Fort Street Public School / Architectural Design Statement  
Section 4.55 Modification 2- Minor Amendments

Department of Education [SSDA 10340-Mod 2] — REV 06 —11/11/2022

Upper Fort Street, Observatory Hill, Sydney

scale	1:200 @ A1	first issued	30/9/19
project code	sheet no.	revision	
FSS	DA-4002	SSDA03

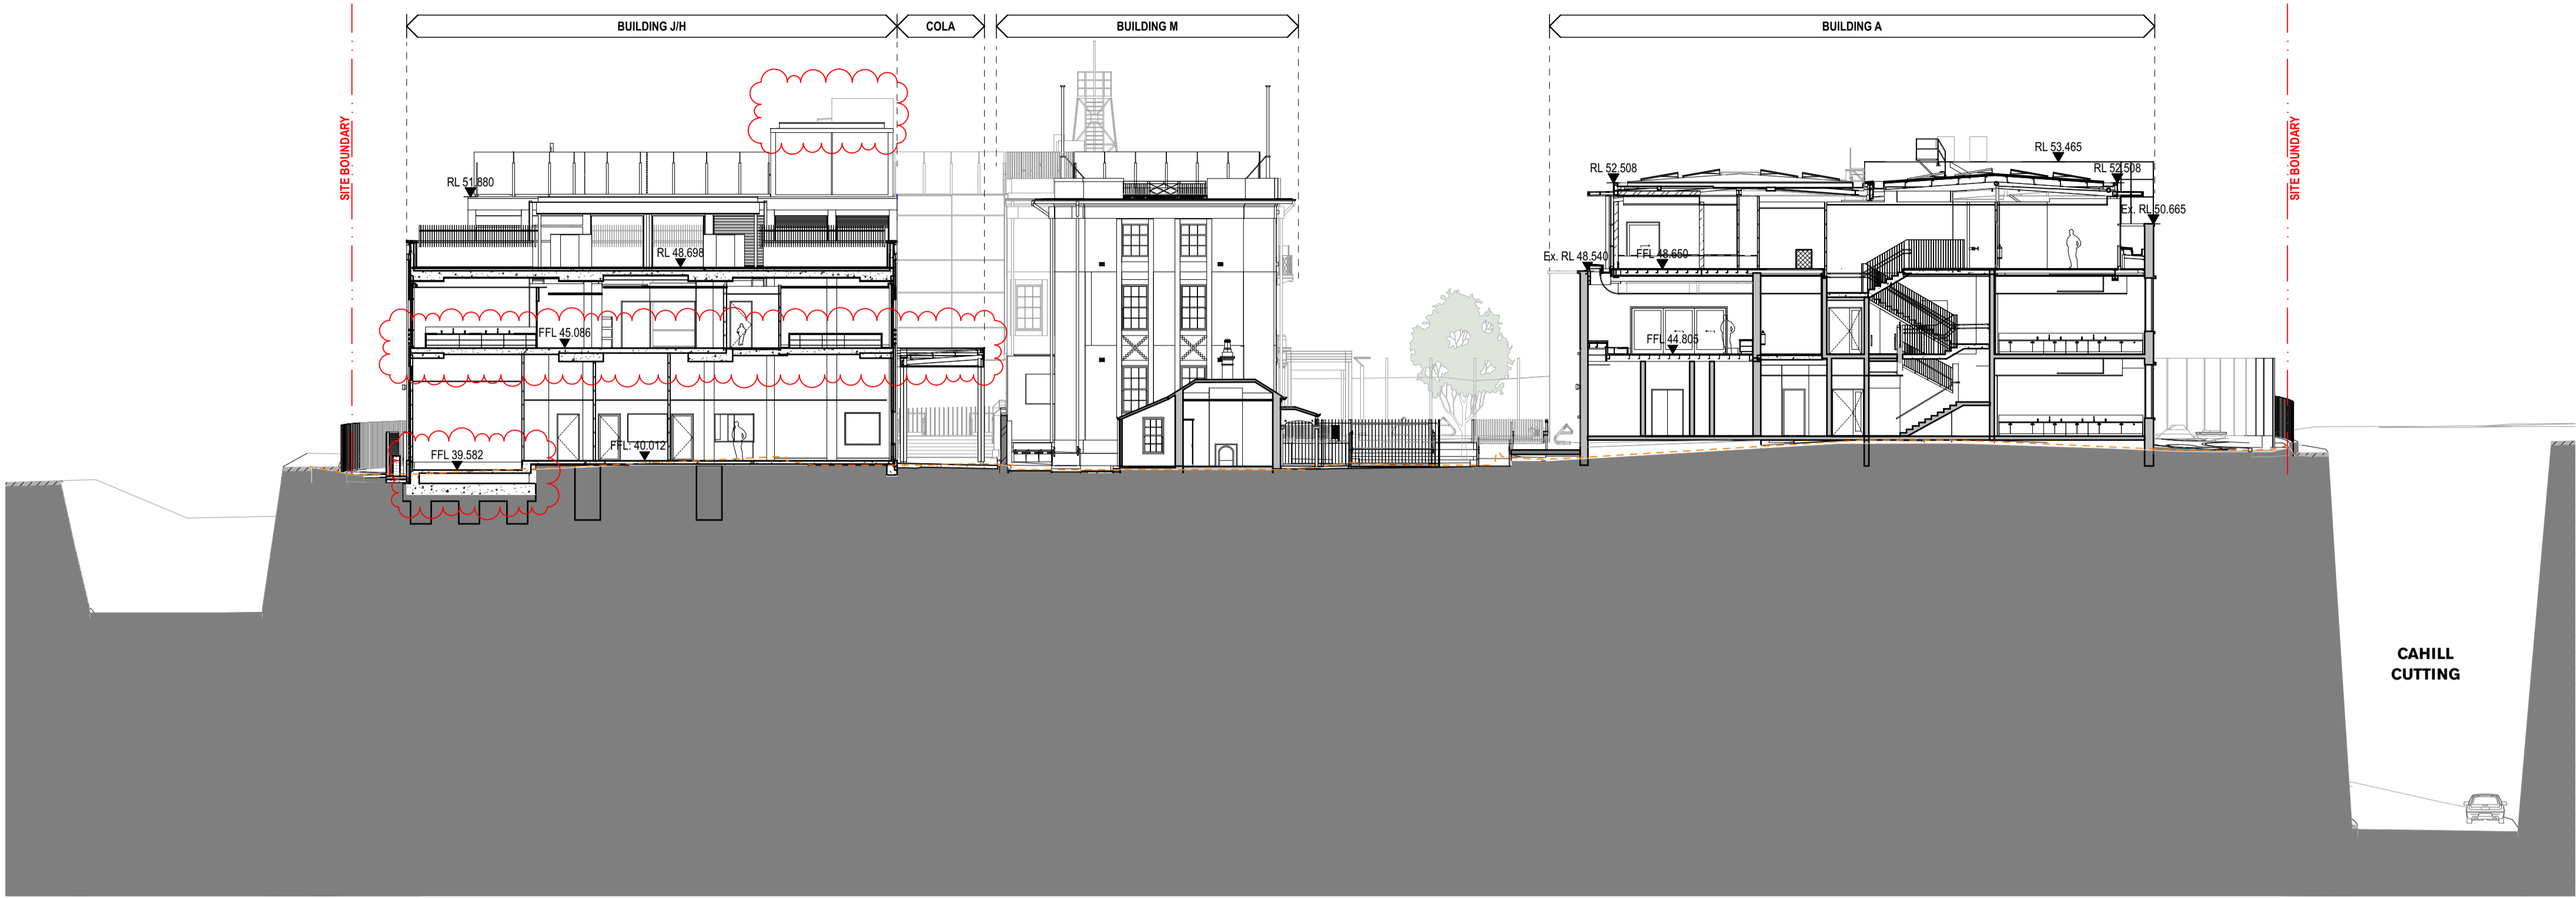
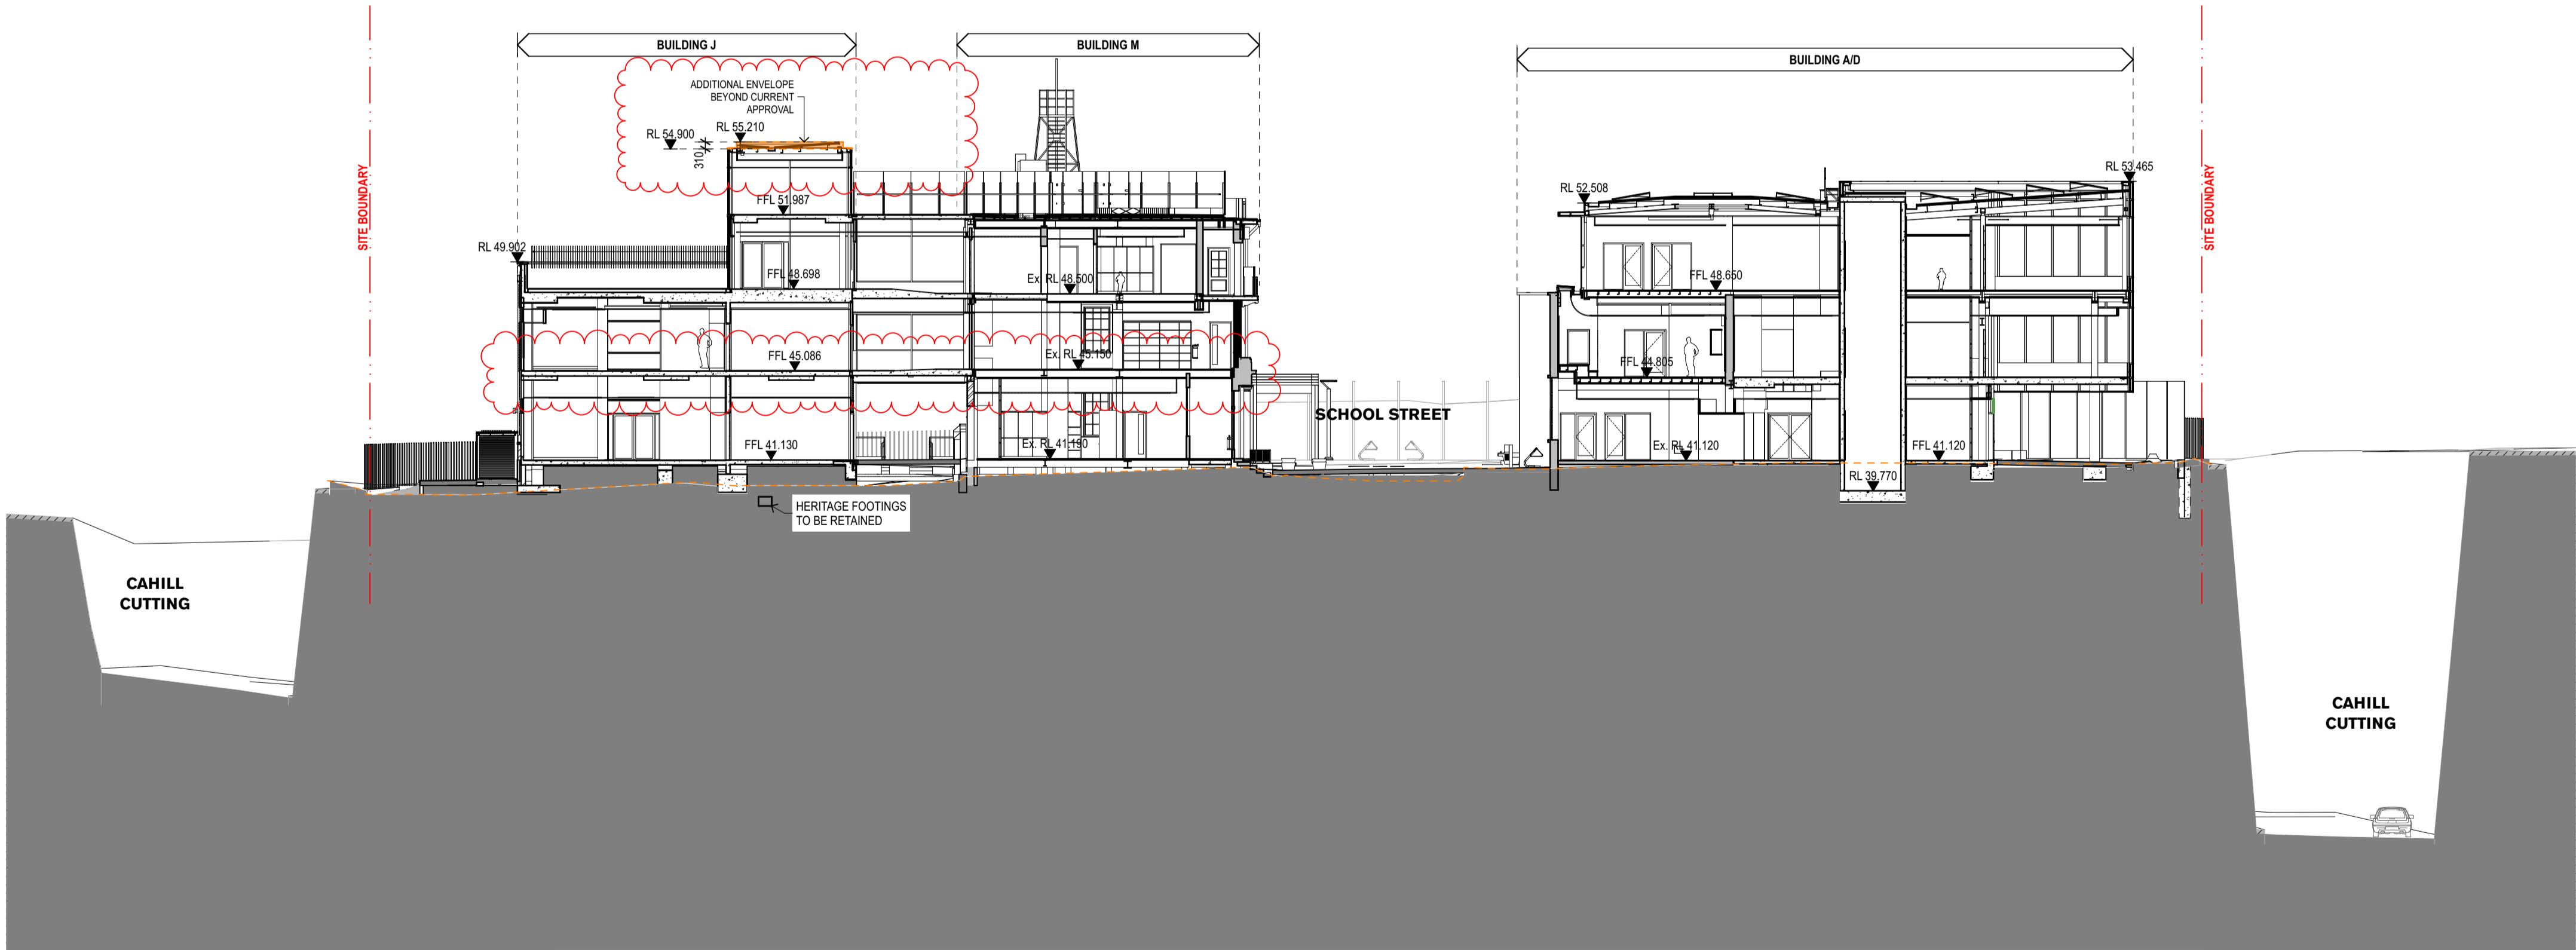
Stair 4 lobby roof	<div>— The proposed increase to the stair and lobby roof is considered to be of greater impact than the raising of the lift shaft, due to its bulk and scale. The Panel notes the constraints of structure and services but none-the-less recommends that further detailed design is undertaken to minimise the height increase.</div>	Drawings were reviewed and considerations for lowering the roof were confirmed showing that further detailed design would not allow a reduction in height. This is due to the size of the sumps , the minimum falls required for the gutter and roof sheeting, and the required size of the steel structure for the roof. Additionally, the roof facade edge detail has been designed to reduce visual impact from below which has been duplicated across the project to retain design consistency.
Stair 4 lobby roof and lift shaft	<div>— The spatial relationship between the lift shaft and the stair lobby roof is considered a minor concern, and the Panel does not believe that the previous relationship between the lift shaft and surrounding foyer roof needs to be maintained.</div>

Materiality / Spandrels	<div>— Renders look different to previous version – confirm if there are material changes?</div>	An addition of solid/opaque fire-rated spandrels and reduced glazing to the MET to Building J/H Bridge and Building J/H/G Glazed facade were required to address fire engineering resolutions to benefit the preservation of the MET fabric. Although this was not shown in the previous SSDA it is required under fire life safety measures.

- lift shaft roof from **RL 55.690** to **RL 56.300**, 610mm increase
- stair lobby roof - **RL 54.900** to **RL 55.210**, 310mm increase
